**St MATTHEWS CATHOLIC COLLEGE, MUDGEES (SSD 9872)
CORNER BROADHEAD ROAD AND BRUCE ROAD, SPRING FLAT (MUDGEES)
RESPONSE TO SUBMISSIONS**

RESPONSE TO DPIE KEY ISSUES AND AGENCY, COUNCIL & PUBLIC SUBMISSIONS

PROJECT No. TX13843.00 - C10.0 DRAWING No. ISSUE E

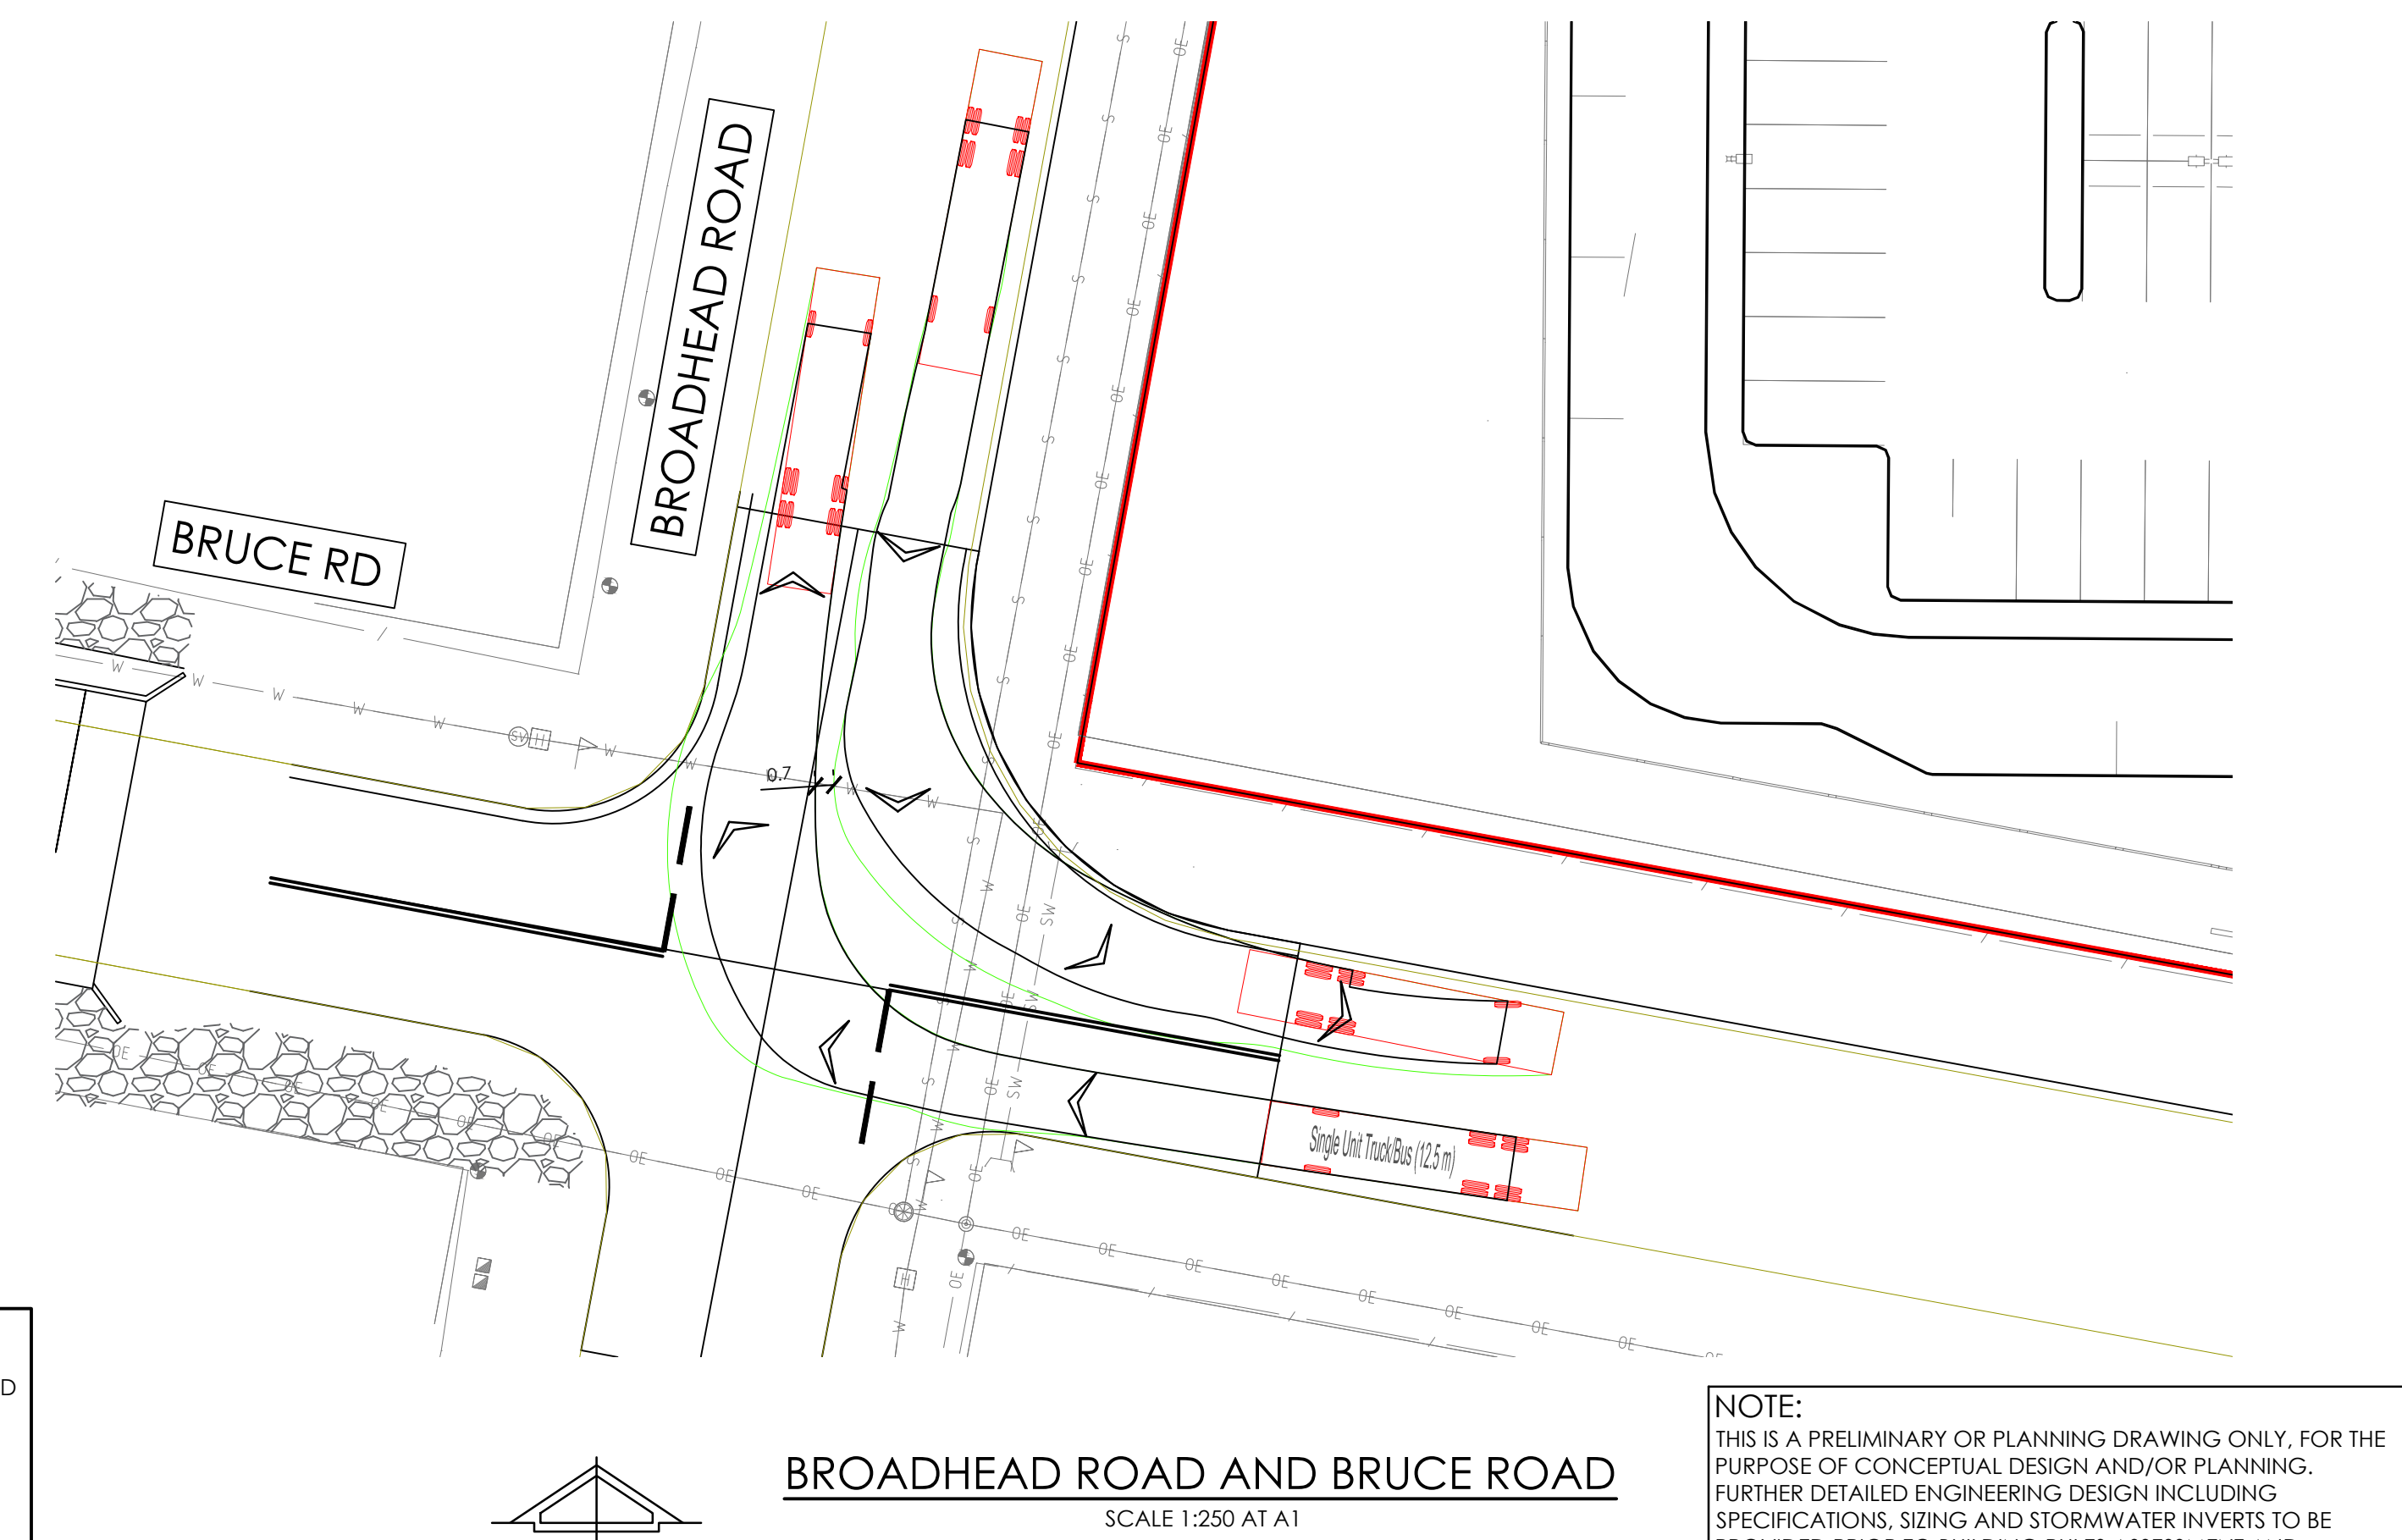
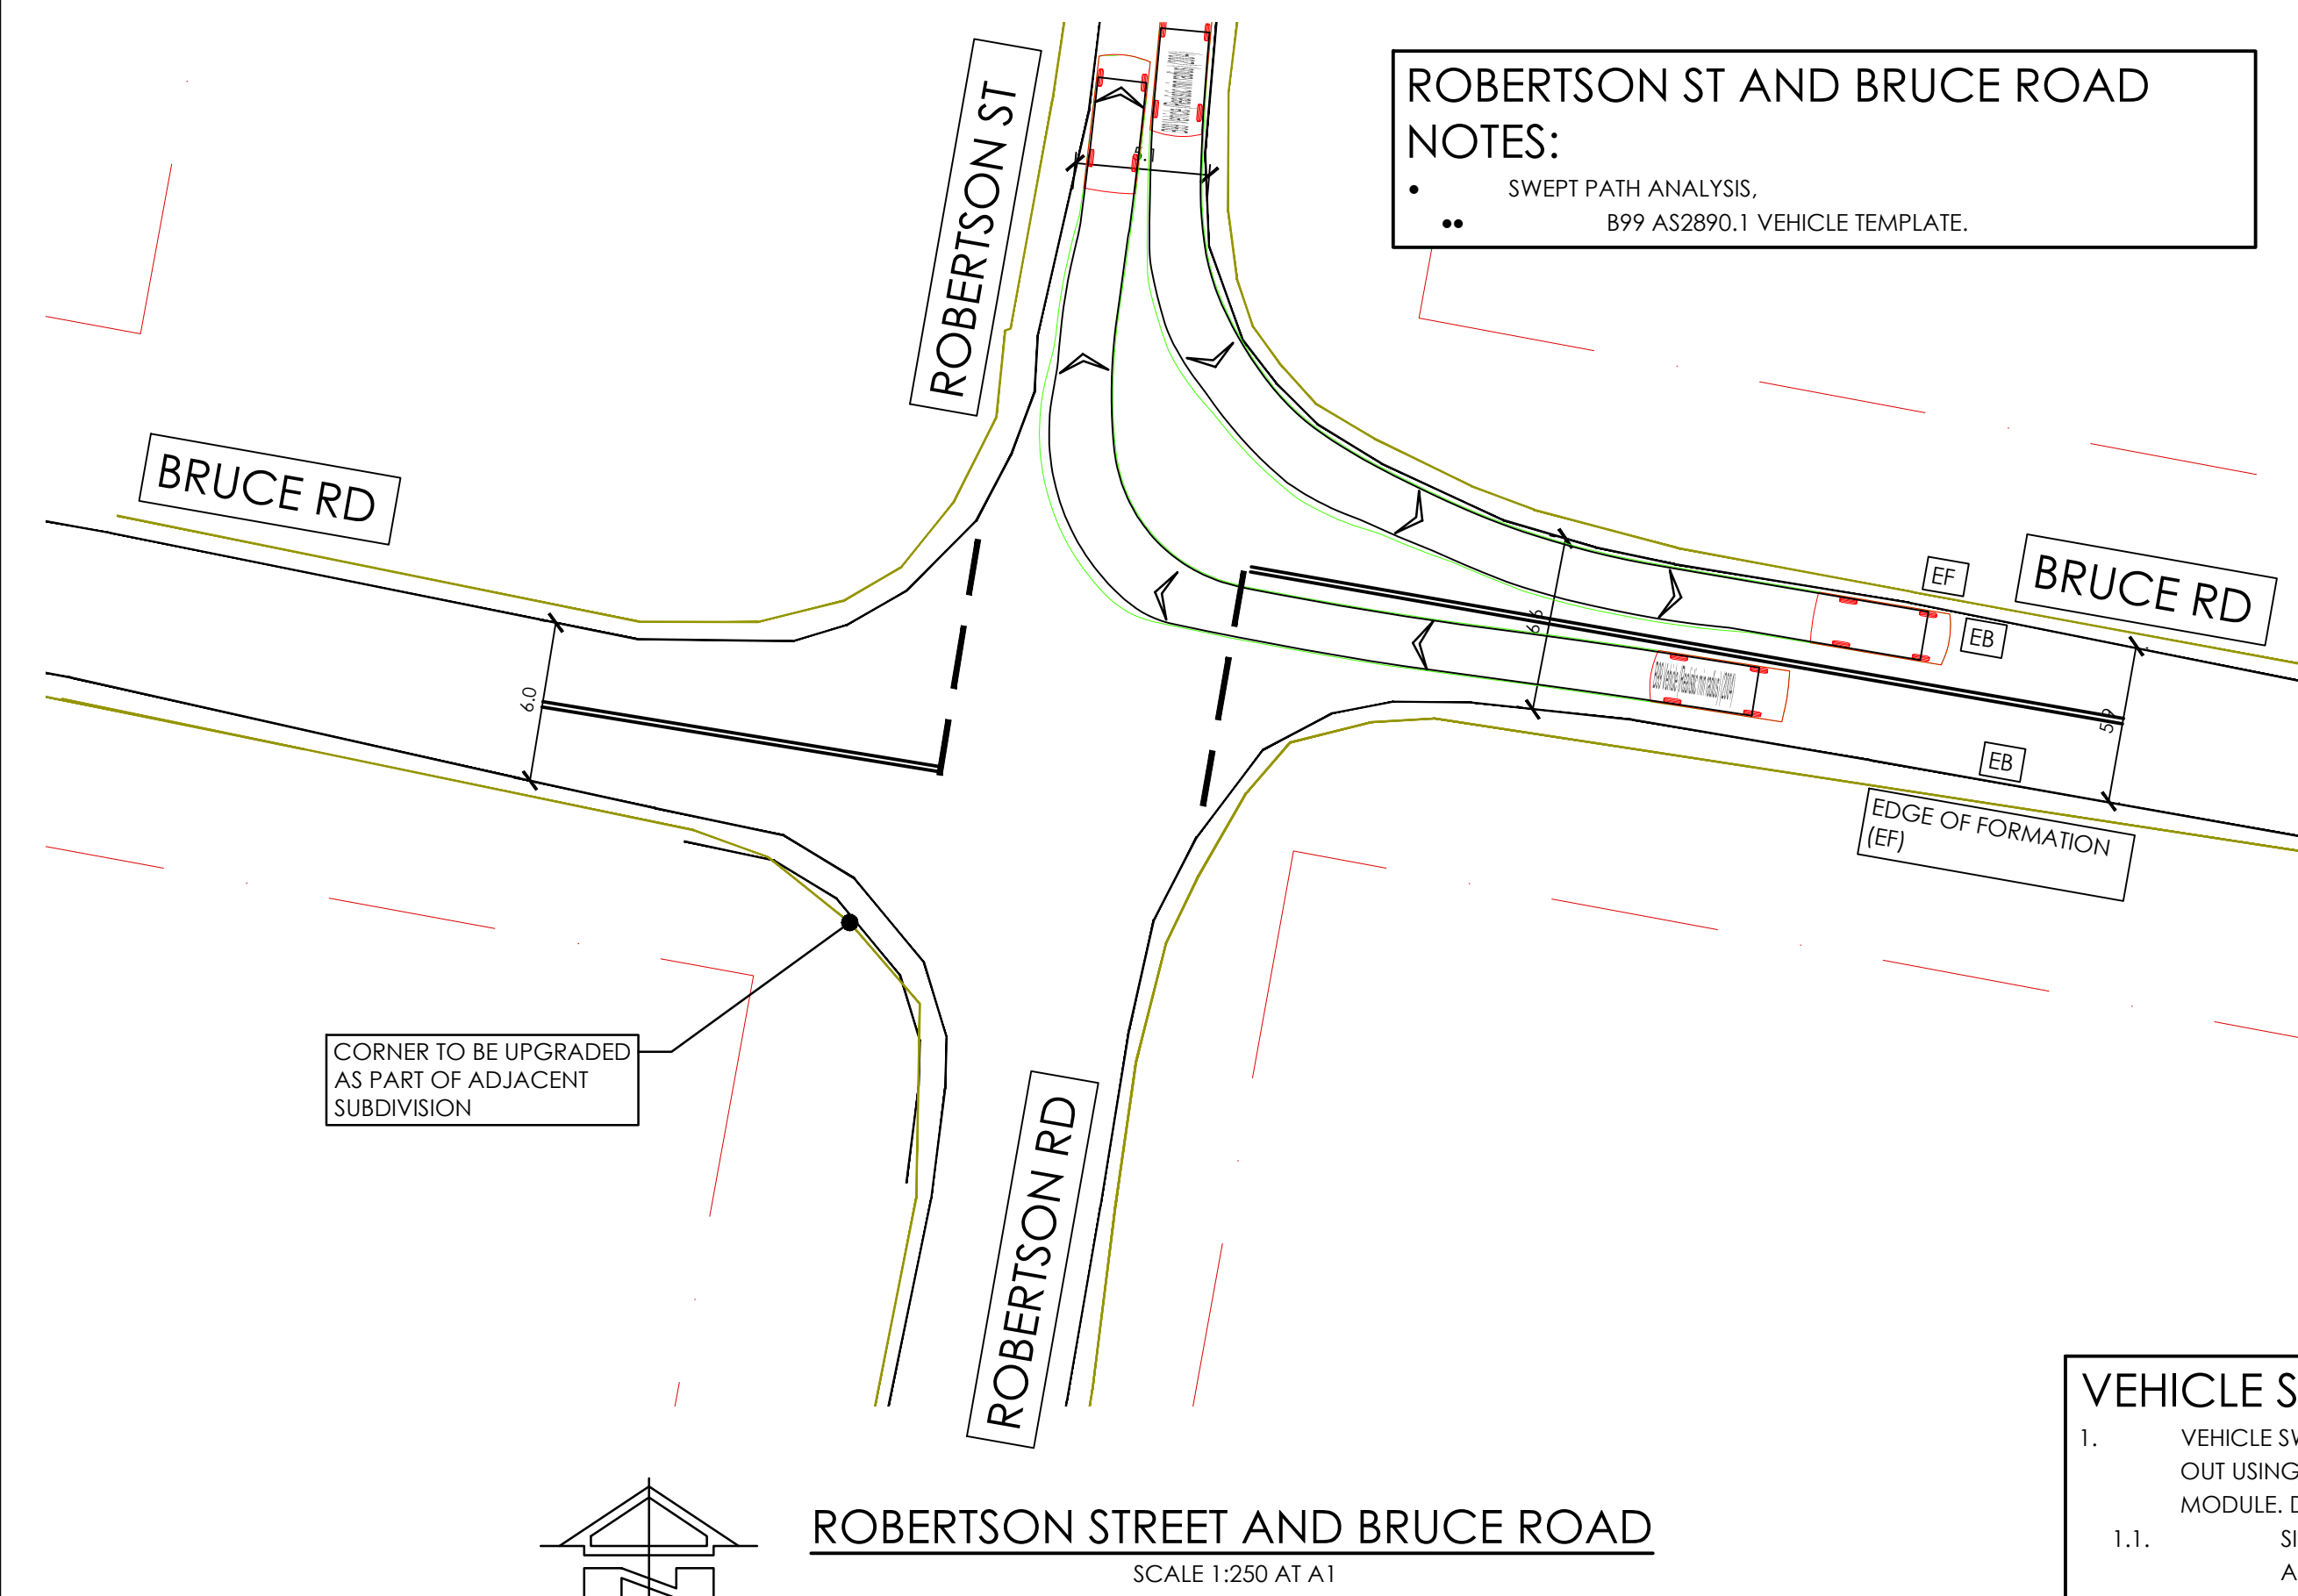
<p>(e) It is not clear from the information provided that buses turning left out of Broadhead Road into Bruce Road can undertake the turn movement in a lane correct manner. Swept path plans are required to demonstrate that turn movements are achievable in a lane correct manner. If the turn movements cannot be made within the correct lanes, an upgrade to the intersection to accommodate the turning movements is required.</p>	<p>A further swept path analysis has been undertaken by Triaxial of the bus turning movement left out of Broadhead Road into Bruce Road in a lane correct manner. The swept path analysis shows that the left-turn movement can be sufficiently accommodated within the traffic lanes without impacting the westbound traffic lane on Bruce Road. Similarly, the opposite movement has also been provided.</p> <p>The swept path plan showing this (and other) manoeuvres is provided in Appendix H.</p>
